Title: **QUALITY AUDIT  
INCLUDING ROAD SAFETY AUDIT STAGE 1  
CASTLEFORBES DEVELOPMENT**

Client: **DBFL Consulting Engineers**

Date: **November 2020**

Report reference: **0899R01**

project ref:			
CASTLEFORBES DEVELOPMENT			
drawing title:			
EASTERN BASEMENT LAYOUT			
client:			
GLENVEAGH			
designed by:	author:	scale:	sheet size:
NJF	BS	1:200	A1
drawing no.:	180159-2102		revision:
			P02

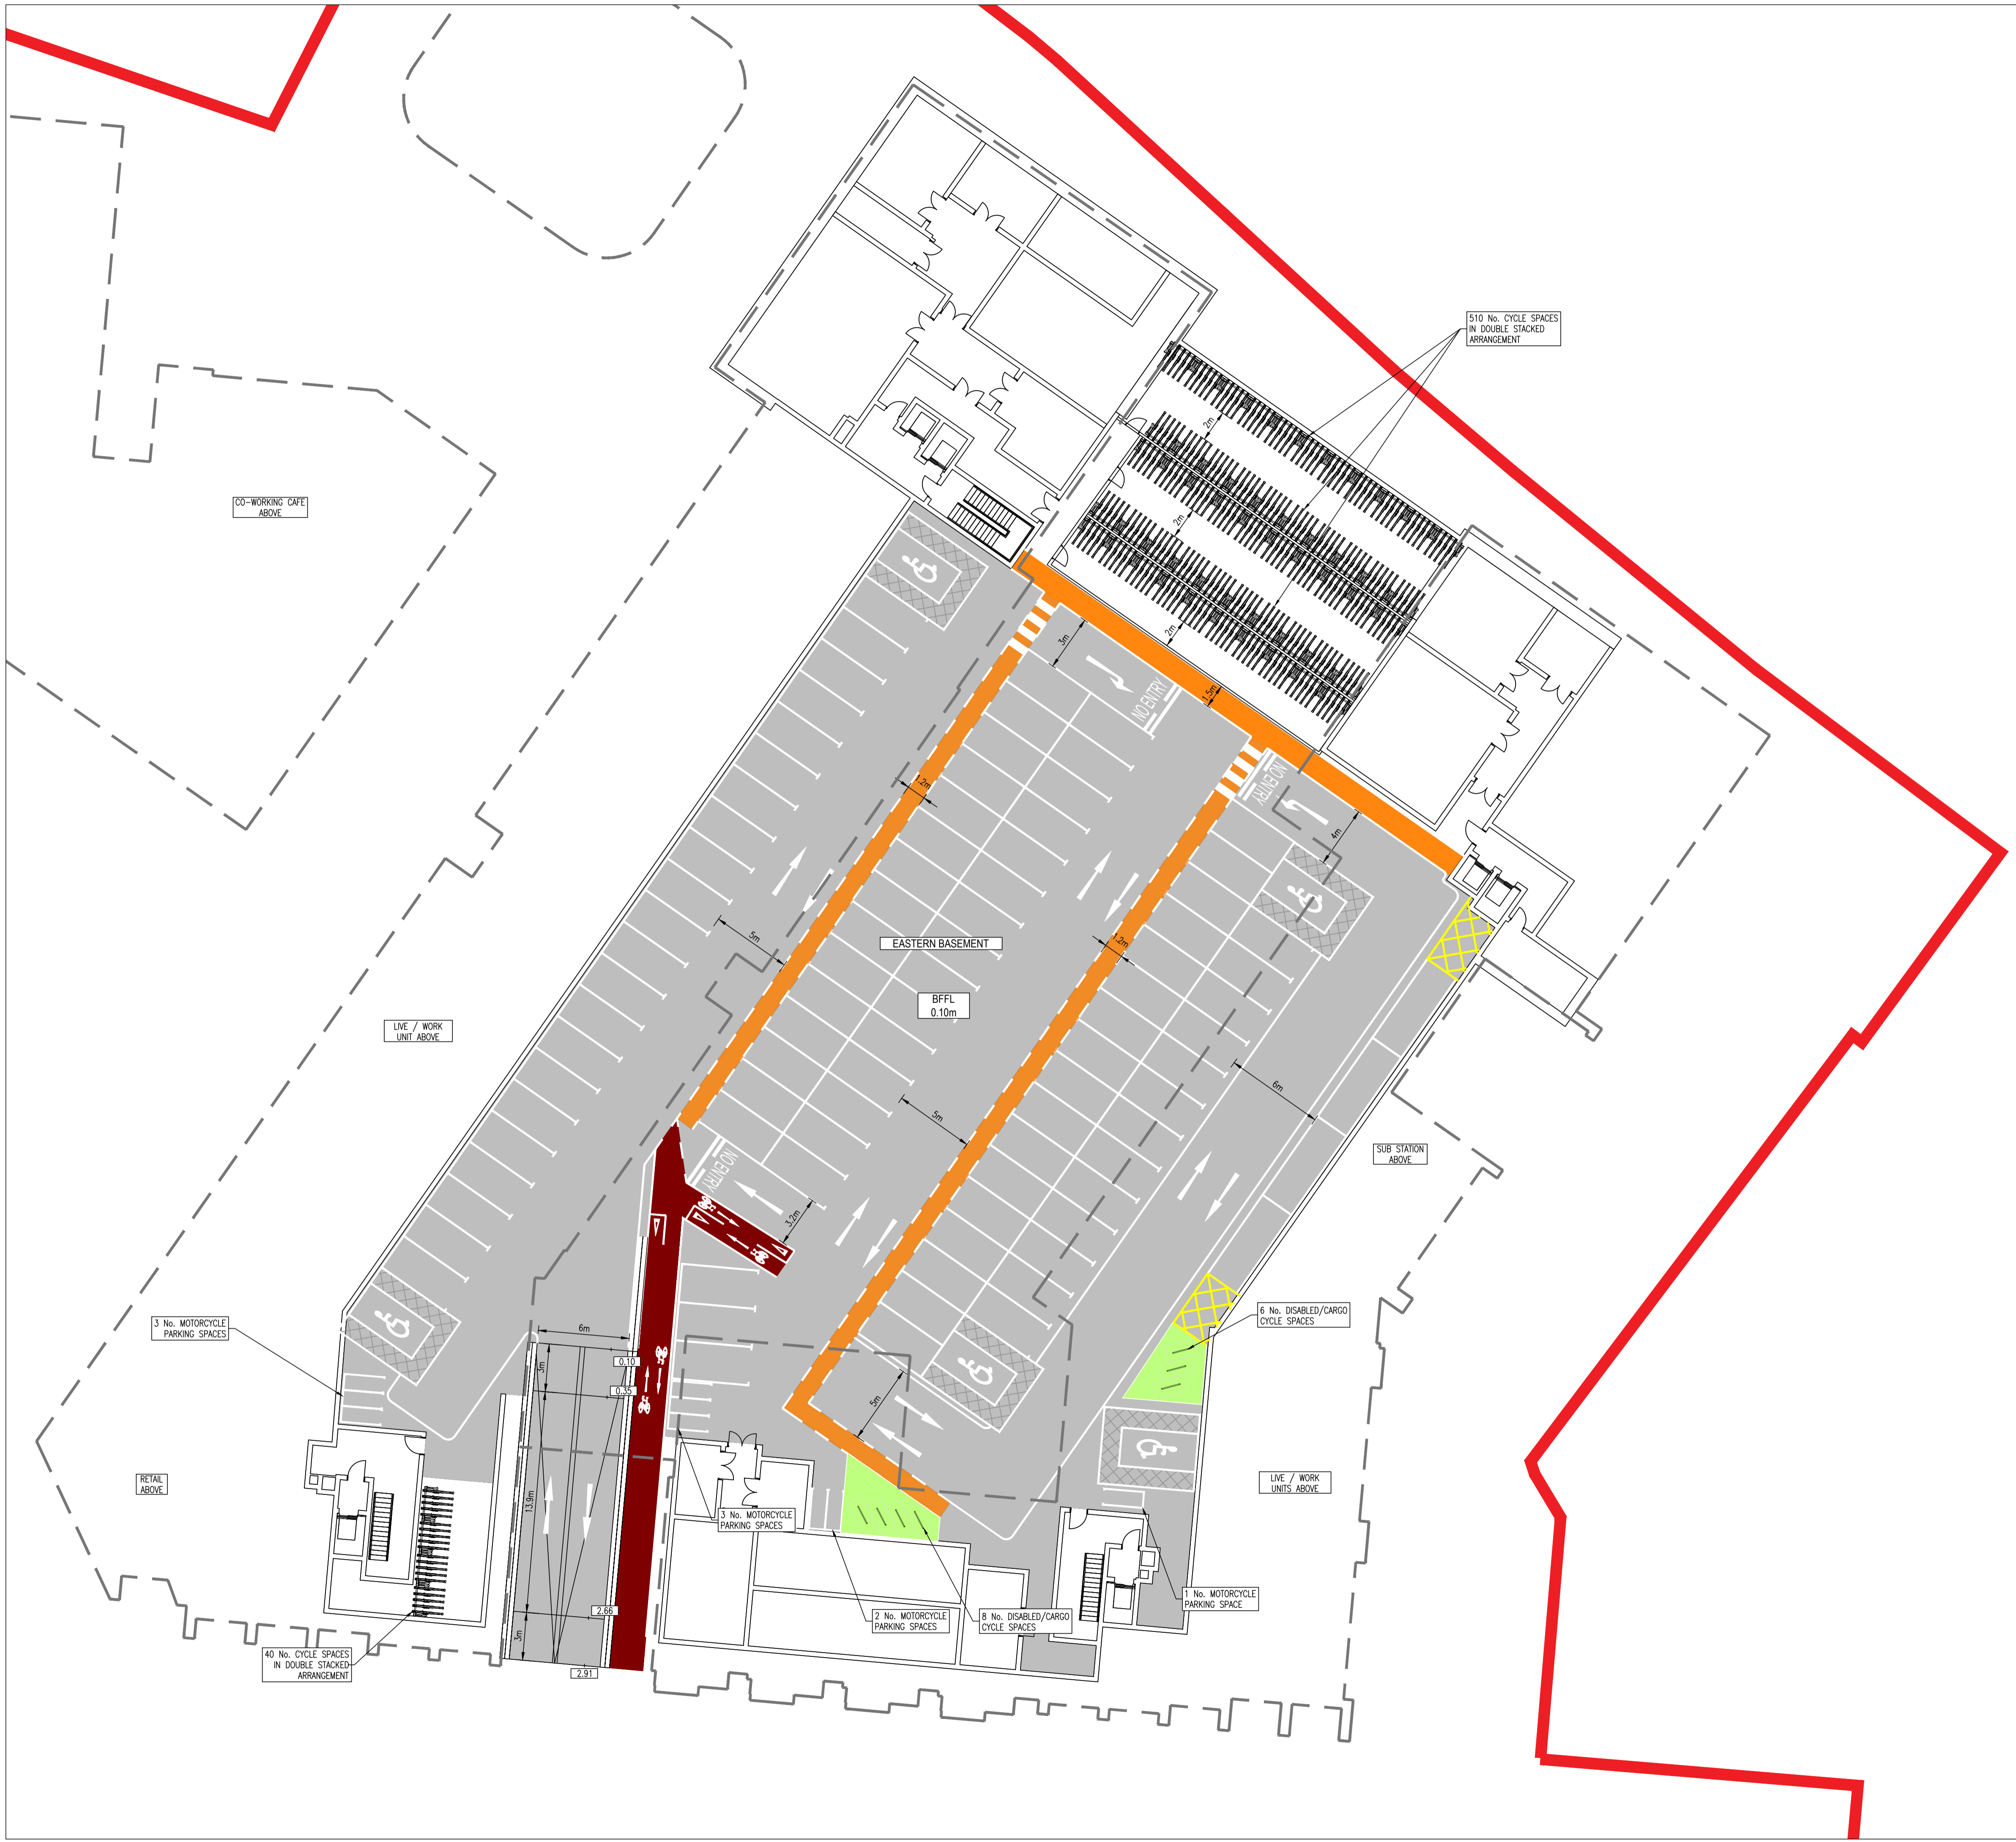
Drawing 180159-2102 Rev P02, Eastern Basement layout.

The basement circulatory layout road markings suggest that there can be two-way traffic on the middle aisle however there is no exit for northeast bound traffic and no turning area if all the spaces are occupied. This could lead to wrong way driving and head-on collisions.

It is recommended that the layout be revised.

3.8	Yes	No	We acknowledge that this concern may arise, however the parking spaces will be assigned to residents of the development and it is unlikely that a vehicle will access the area without the intention of parking. To accommodate the unlikely event of this occurring, the aisle will be made one way at detailed design.	Yes

Project: Castleforbes		Project No: 6608	
Dwg: Proposed Site Landscape Layout		Drawing No: 6608_0300	
Scales: 1:500 @ A1		Status: Planning	
Date: October 2020		Rev: -	
Canal House, Canal Road, Dublin 6 Tel: +353(0)1 2061900		Dm: CB-CS

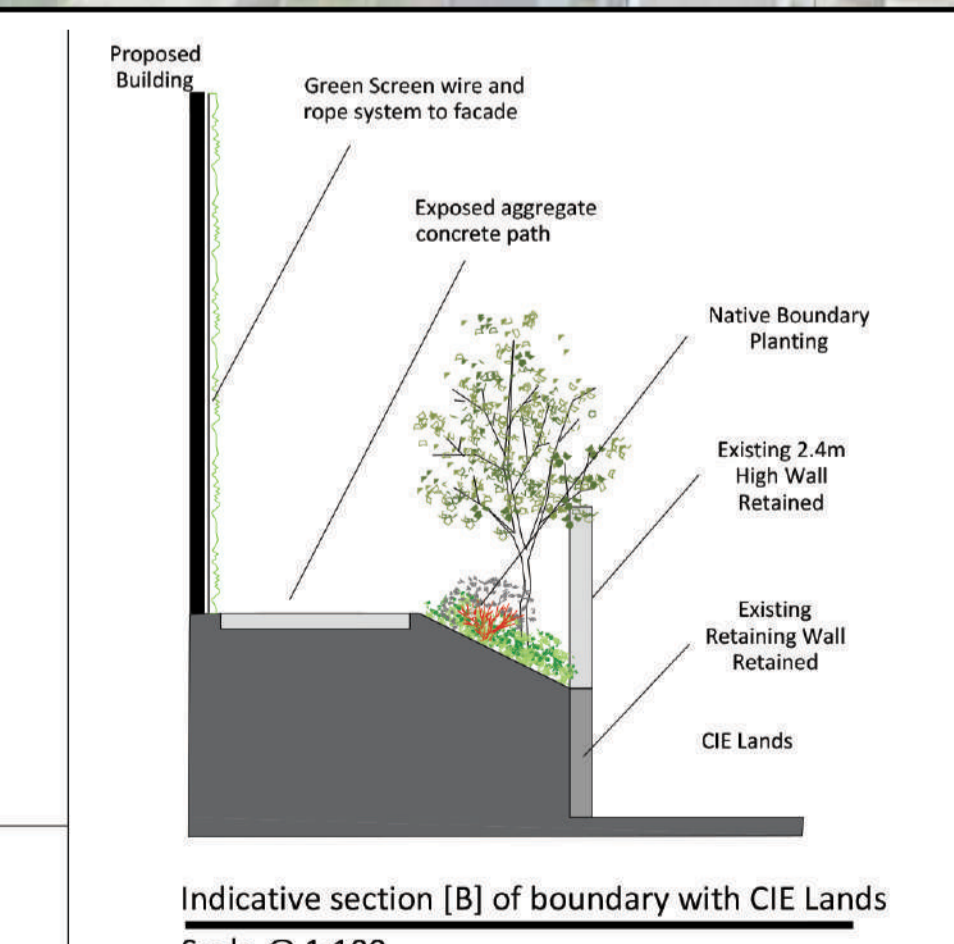
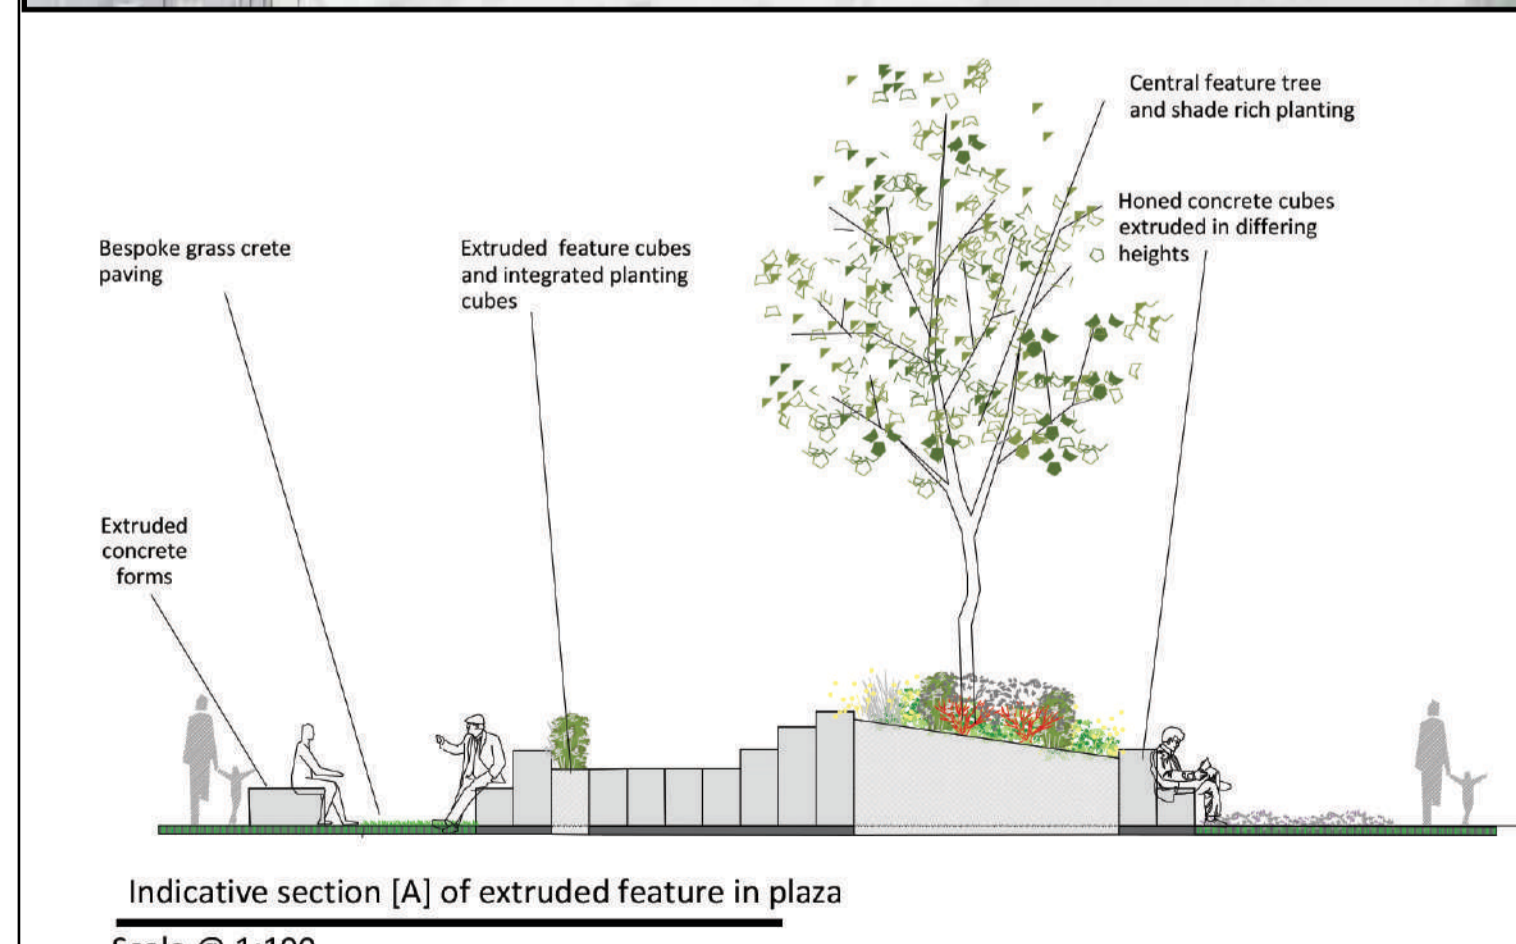
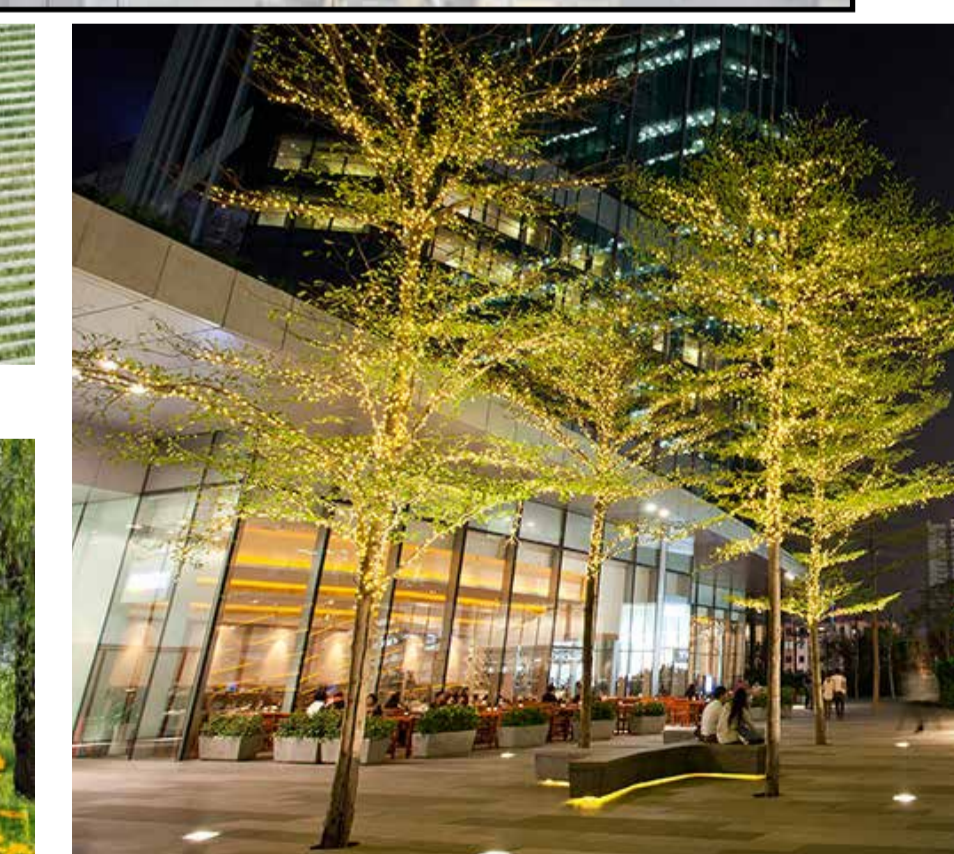
Drawing 6608\_0300 Rev – Proposed Site Landscape Layout.

There is a risk that the proposed trees along the edge of the carriageway will block visibility to signal heads (either primary or secondary) which could result in collisions.

It is recommended that trees be removed from in front of traffic signals and from within visibility splays.

stop. Should DCC allow the applicant to relocate the bus stop, and grant the necessary licenses, then same will be facilitated.	
3.3	Yes	Yes		
3.4	Yes	Yes
